**Planning Department
Transportation Development Services**

June 17, 2015

**Re: Blue Linx Warehouse Adaptive Re-Use Project
1820 Bellamah Ave., NW
Traffic Circulation Layout
Engineer's/Architect's Stamp dated 5-26-15 (J13-D101)**

Project no. 1407
sheet
A-1.2
4 of 25
date 1-15-16

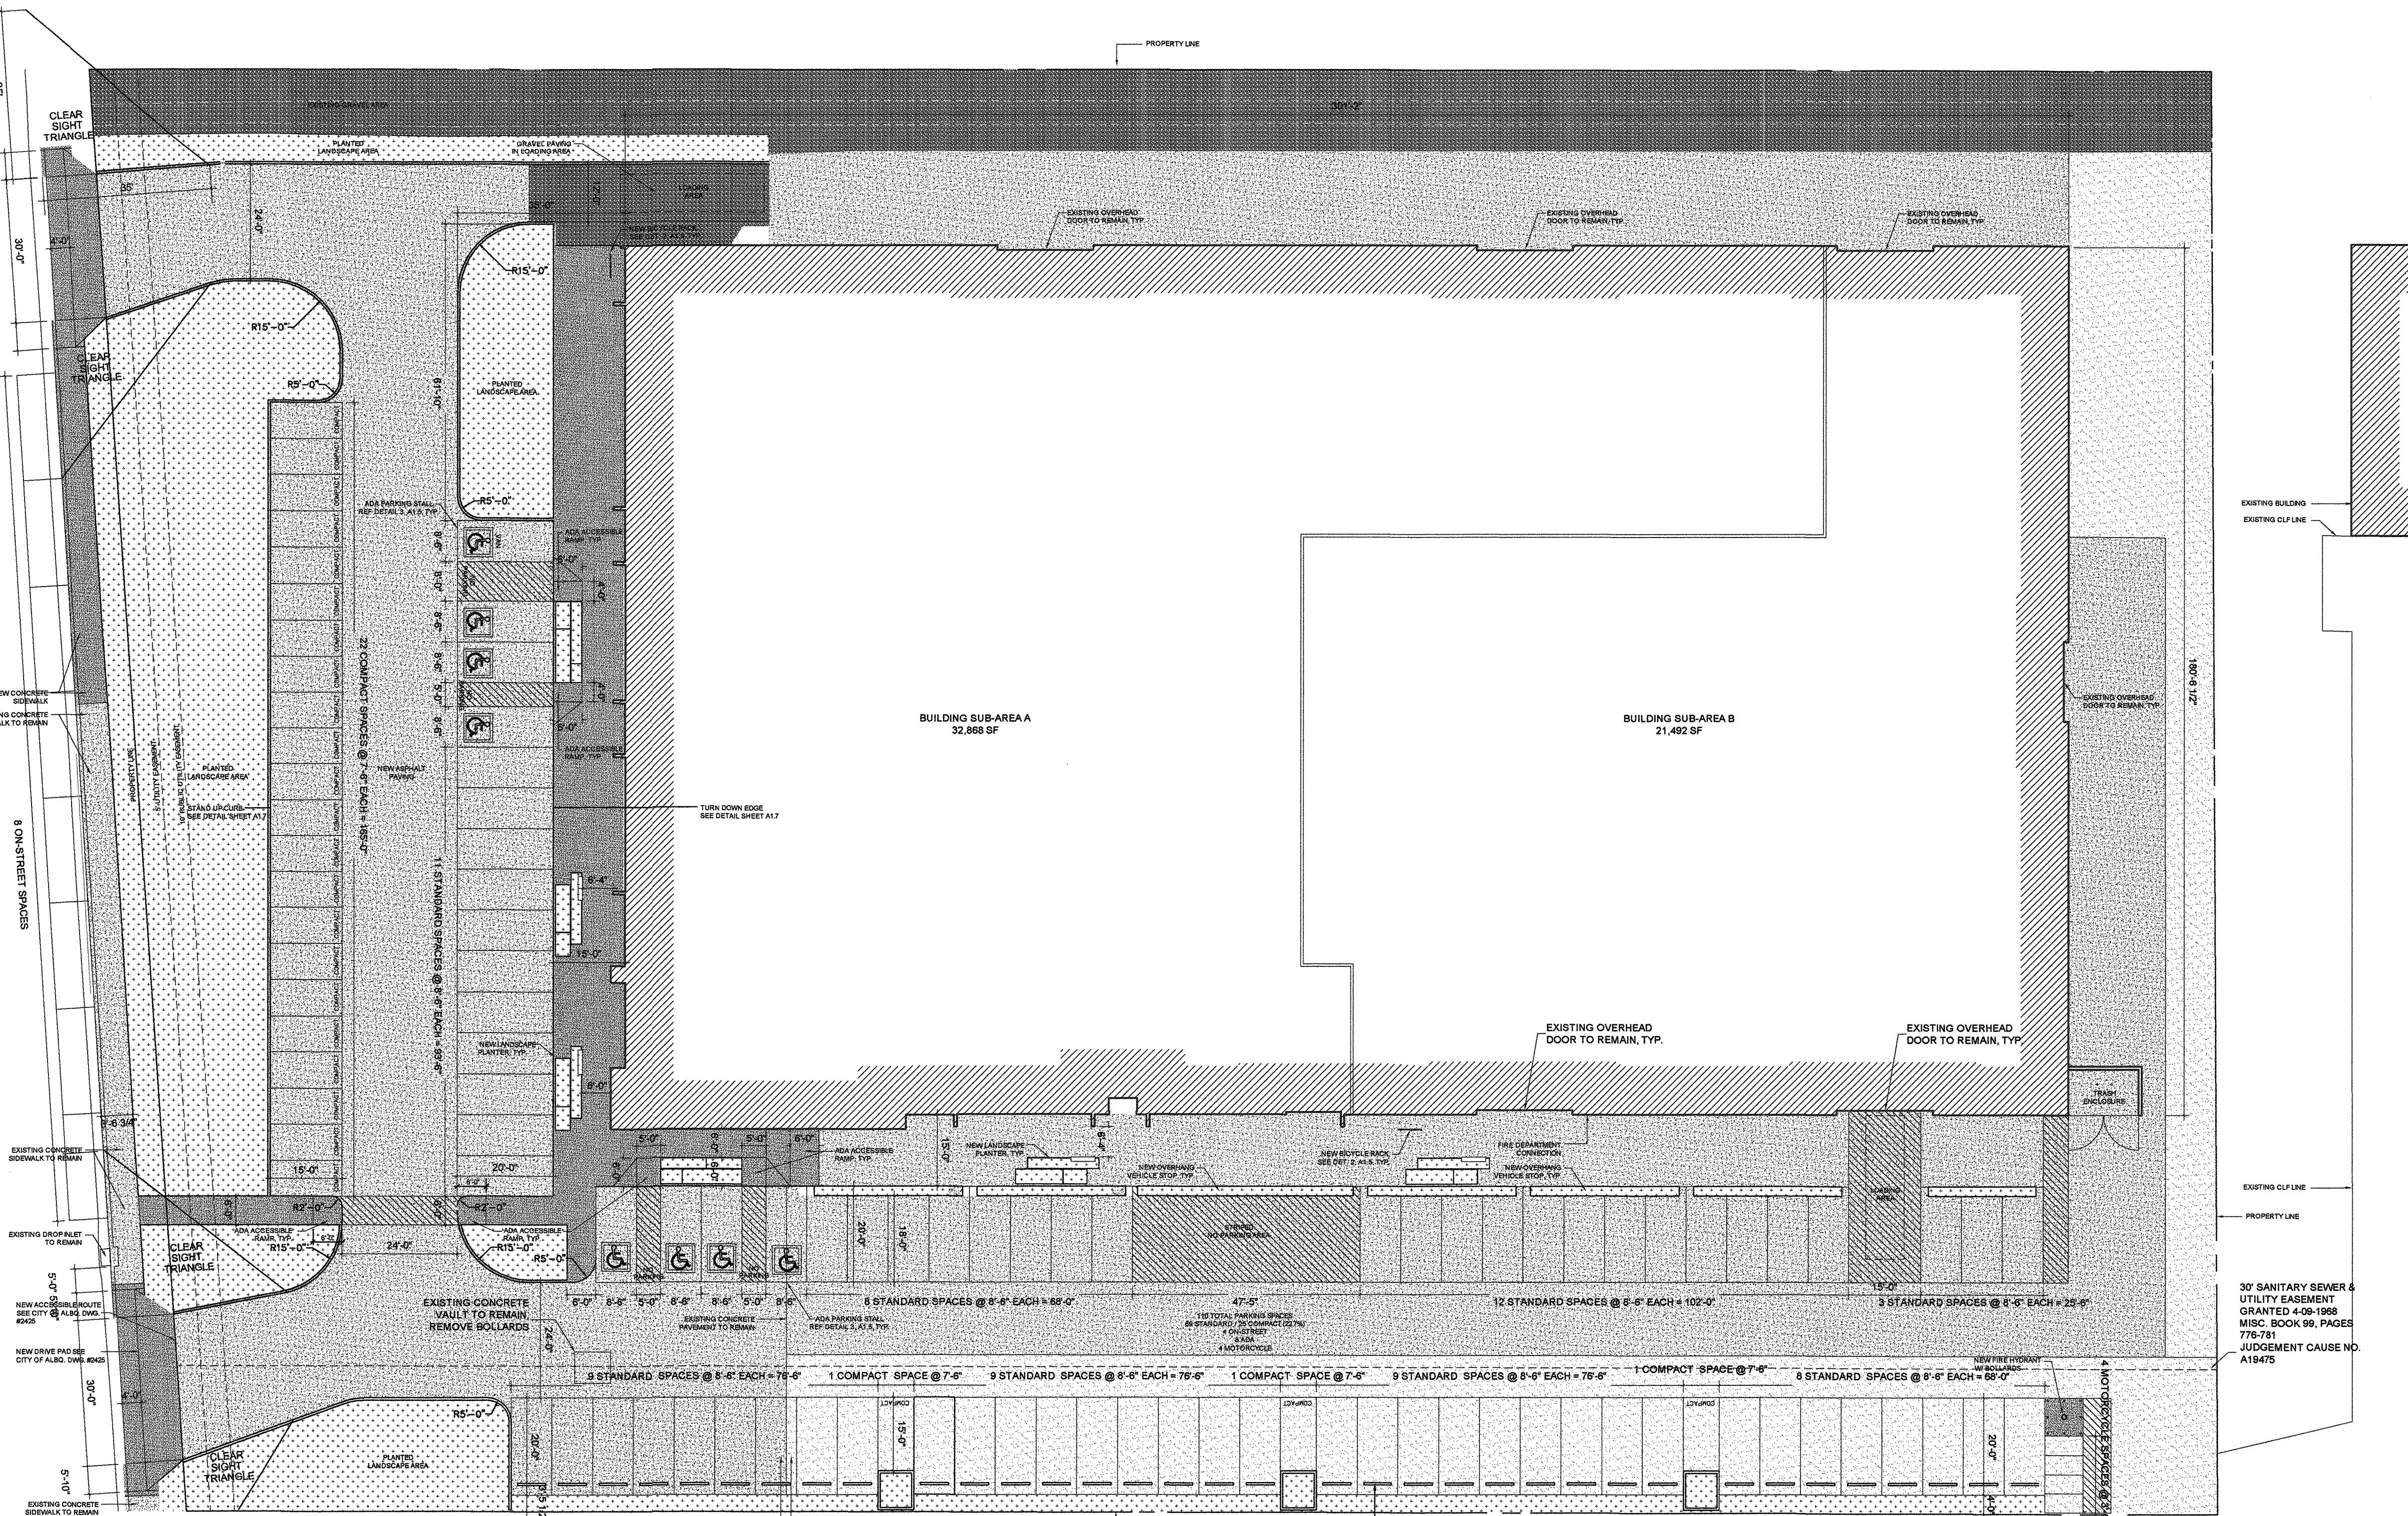
1. Identify the right of way width, medians, curb cuts, and street widths on Bellemah Ave., 18th St. and 19th St.
2. Please detail "Overhang Vehicle Stops" on west side of building and call out Turn Down Edge bumper stops on north side of building.

3. Please refer to the Fire Marshall regarding parking space in front of Fire Department Connection point, stripping might be required.
4. The ADA accessible sign must have the required language per 66-7-352.4C NMSA 1978 **"Violators Are Subject to a Fine and/or Towing."**

5. The ADA access aisle shall have the words **"NO PARKING"** in capital letters, each of which shall be at least one foot high and at least two inches wide, placed at the rear of the parking space so as to be close to where an adjacent vehicle's rear tire would be placed. (66-1-4.1.B NMSA 1978)

6. Please detail and dimension ADA ramps from handicap parking to building entrances on north and west sides of the building.
7. Provide a min 6" or max 8" high concrete barrier curb or other acceptable barrier between landscaping and parking areas and/or drive aisles. Please call out barrier curb, turndown edge and overhang wheel stop locations.

8. Design delivery vehicle route needs to be shown.
9. Service vehicle and/or refuse vehicle maneuvering must be contained on-site; provide a copy of refuse approval.

10. Please provide a sight distance exhibit (see the *Development Process Manual, Chapter 23, Section 3, Part D.5 Intersection Sight Distance*). Please show this detail for both the entrances on Bellamah Ave.

11. Please add the following note to the clear sight triangle: "Landscaping and signage will not interfere with clear sight requirements. Therefore, signs, walls, trees, and shrubbery between 3 and 8 feet tall (as measured from the gutter pan) will not be acceptable in this area."
12. Please include two copies of the traffic circulation layout at the next submittal.
